Please add "PCD File No. COM-21-028"

Project Name:
**LEANN WILSON & ASSOCIATES
 NEW OFFICE BUILDING**
 SHEET NAME:
 SITE PLAN

Site Plan_V1_Redlines.pdf Markup Summary

Sheet No: C-2
 Project No: 04-048
 Date: 7/19/05
 Rev: Δ
 RBD:
 OWNER:
 GC:

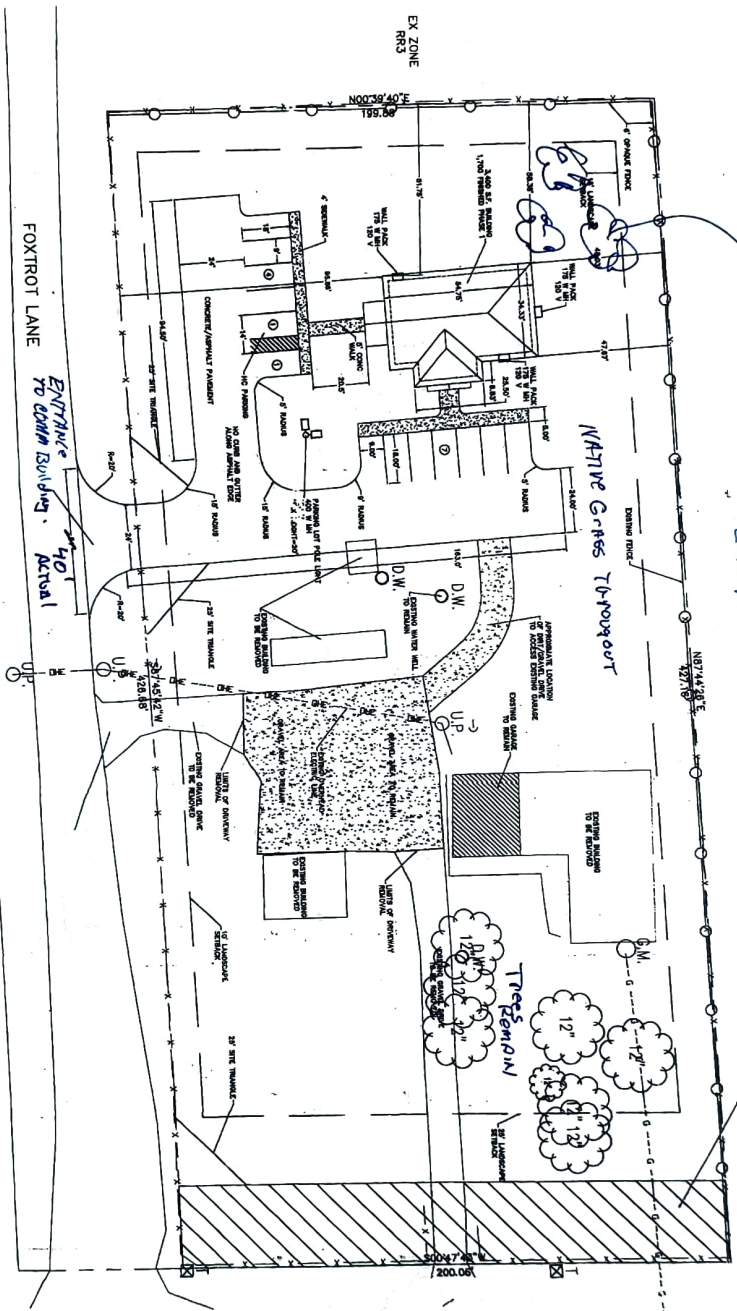
Landscape requirements for commercial uses per LDC CH. 6 apply, pursuant to the below applicability subsection:

Please note that landscaped areas (including no. of trees) within required landscape buffer areas, as well as parking areas, do not count toward internal landscaping requirement. Internal landscaping shall either be:

1. Adjacent to the building;
2. At all pedestrian entrances;
3. Within a plaza or courtyard;
4. In an area provided to separate building from parking lot; or
5. In an area provided to separate building from parking lot; or
5. In an area provided to separate building from parking lot; or

Please refer to all landscape standards within LDC Chapter 6 and revise site landscaping to comply. If landscaping requirements will not comply, then an alternative landscape plan may be proposed and justified according to the criteria outlined in the below snip from Ch. 6 of the LDC:

Some components of this plan are outdated, including the property's zoning designation, which is now CC. (Also, Max building height for the CC district is 40', not 30', etc.)

Also, the property size shows as 1.82 on the Assessor, not 1.96.

Please revise the plan accordingly throughout.

Please apply for a commercial driveway access permit. Contact Petra Rangel at petrarangel@elpasoco.com for assistance in obtaining one.

Per ECM 2.4.1.E.3, two way commercial driveways can be a maximum of 40 foot access width. Please revise to meet criteria.

This plan is outdated, so the parking requirements are now out of date and incorrect, too. The parking requirement is 1 space per 200 SF. The parking and maneuvering standards of LDC Ch. 6 do not apply/ are not triggered for this COM project per the applicability subsection within the parking standards, so the existing parking will not be required to meet current code standards. However, please revise the parking table here to be accurate with the current parking ratio in Ch. 6 parking standards.

Please revise the plan date and remove the approval items here from the previous site plan approval in 2005. This is to clear up any confusion that may arise.
